# CITY OF ALBUQUERQUE

March 23, 2018

**Re: The Carlisle  
3600 Central Ave SE  
30-Day Temporary Certificate of Occupancy- Transportation Development  
Transportation Development Final Inspection  
Architect's Stamp dated 11-23-15 (K17-D069)  
Certification dated 03-22-18**

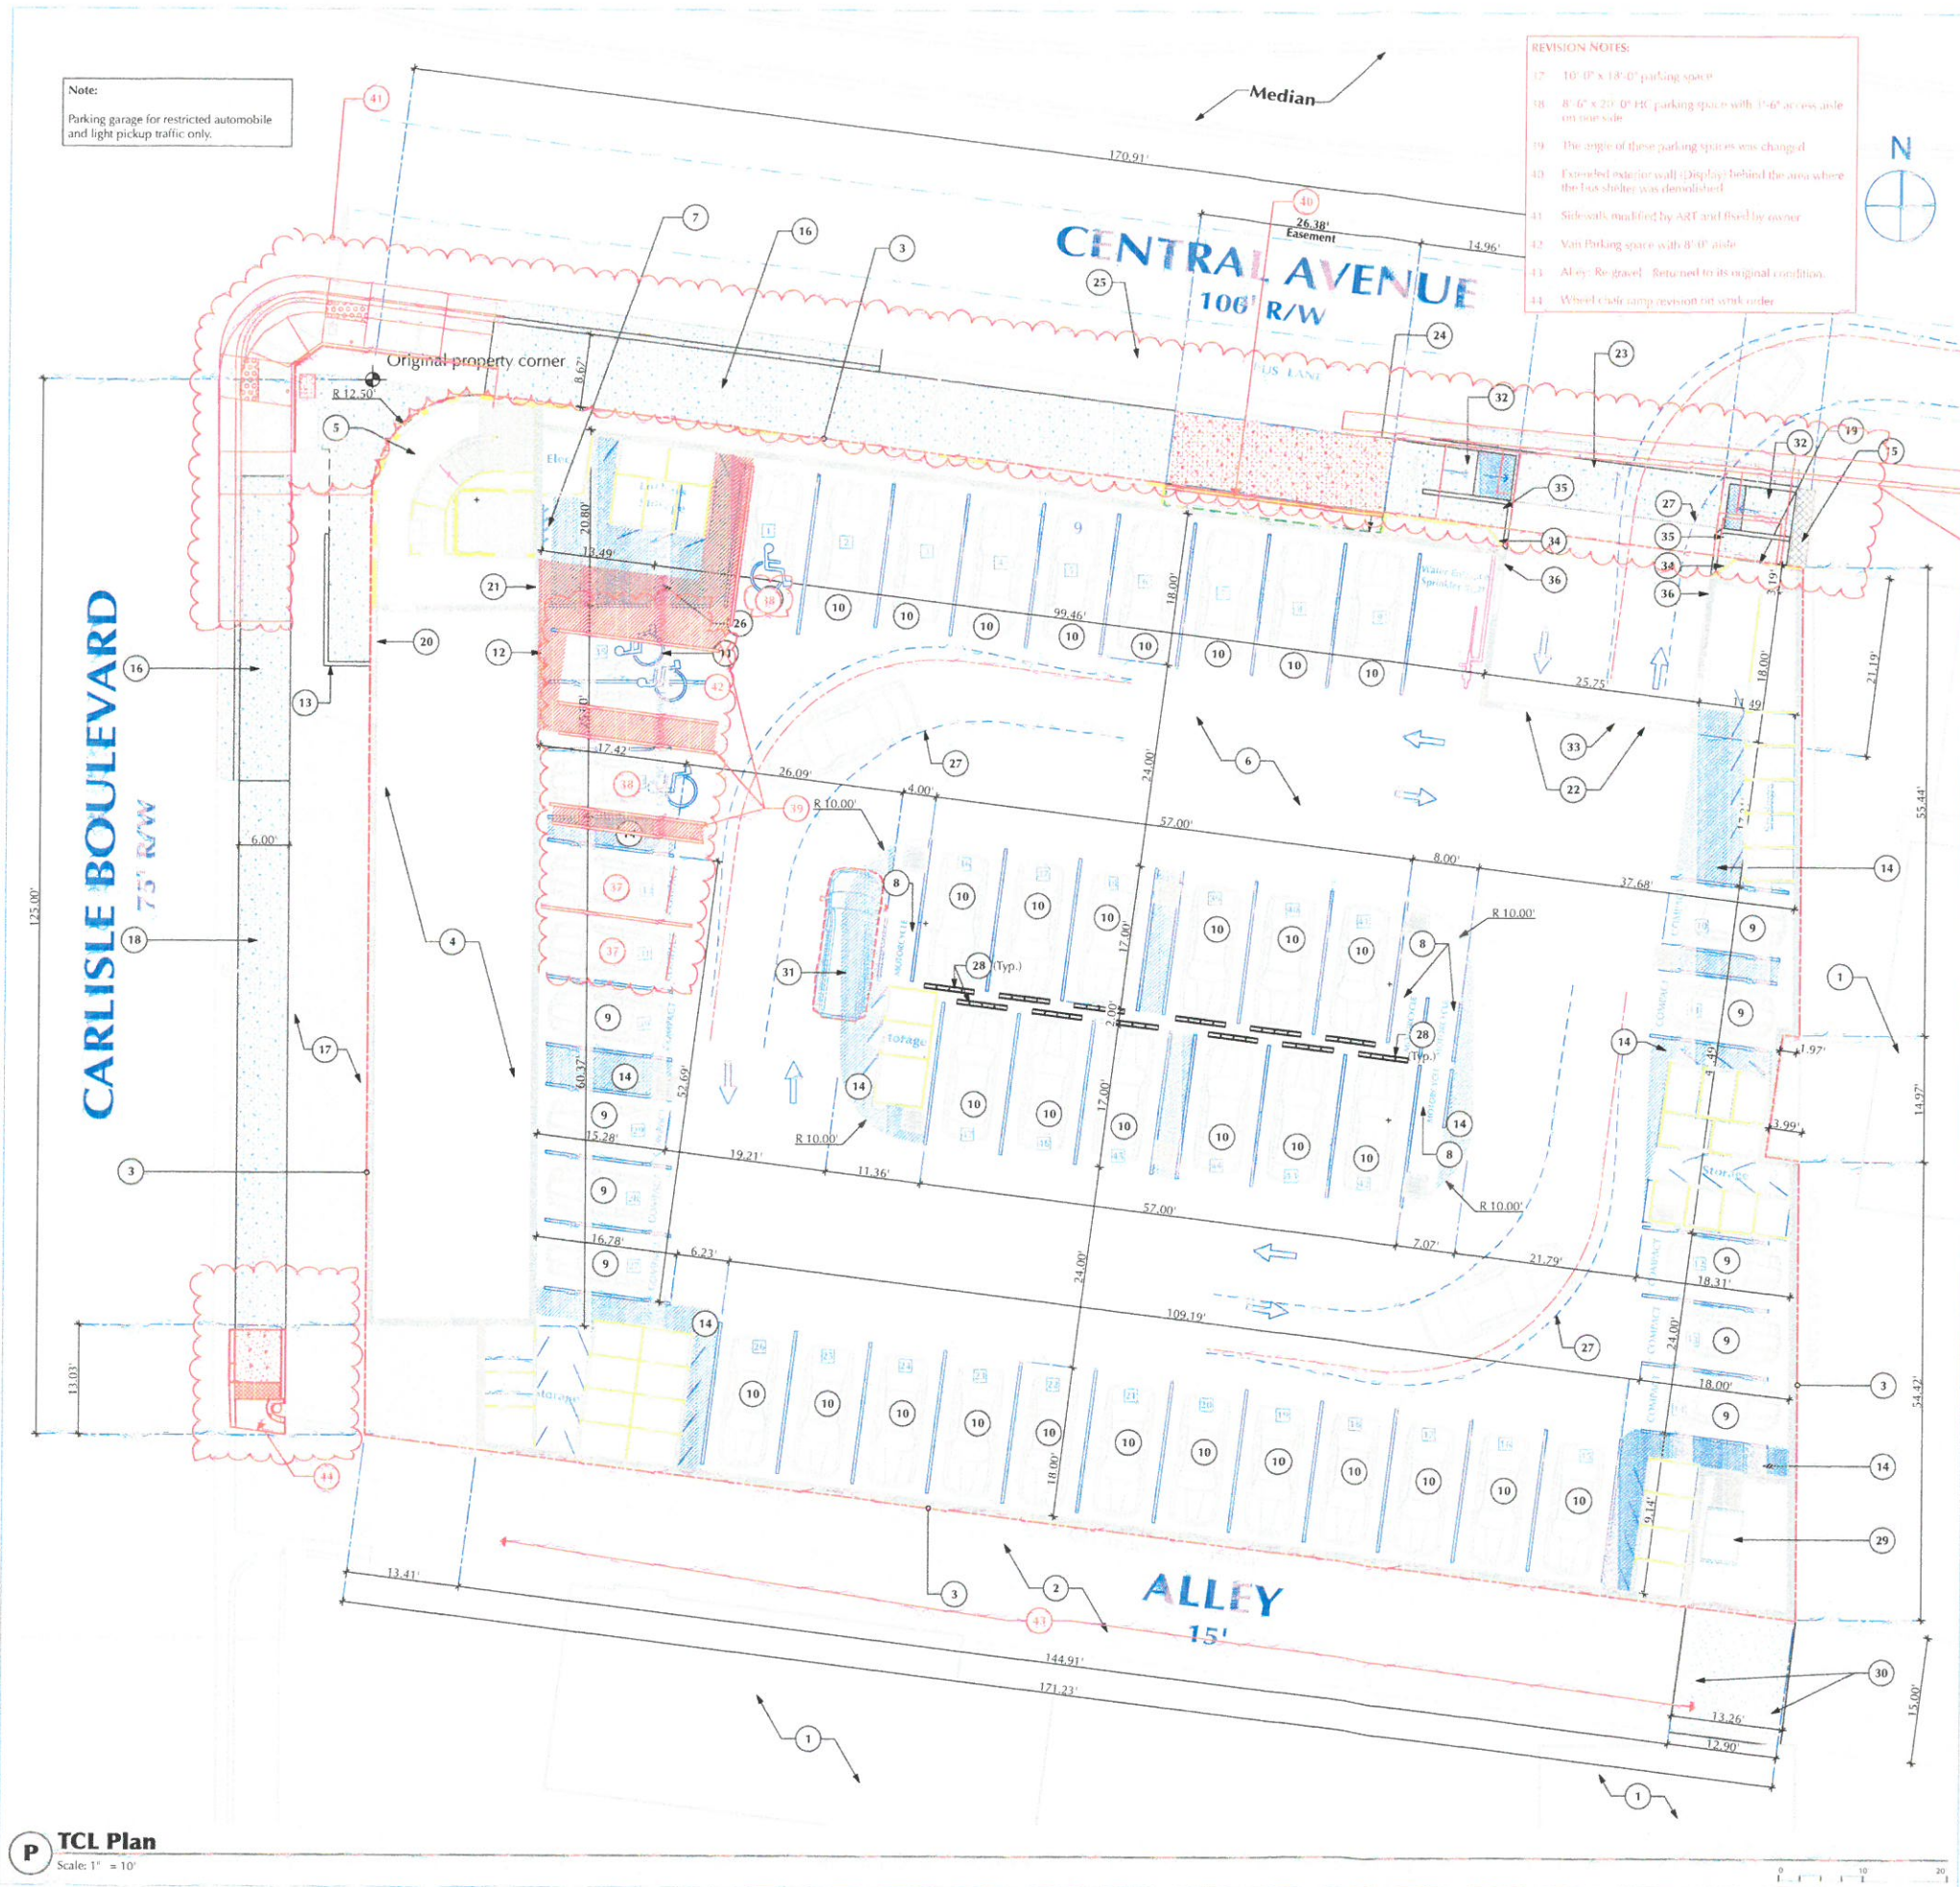
1. The City Work Order must be accepted and closed.
2. The sidewalk stone missing next to the power pole on Carlisle Ave must be installed and the connection to the side of the building must be addressed.
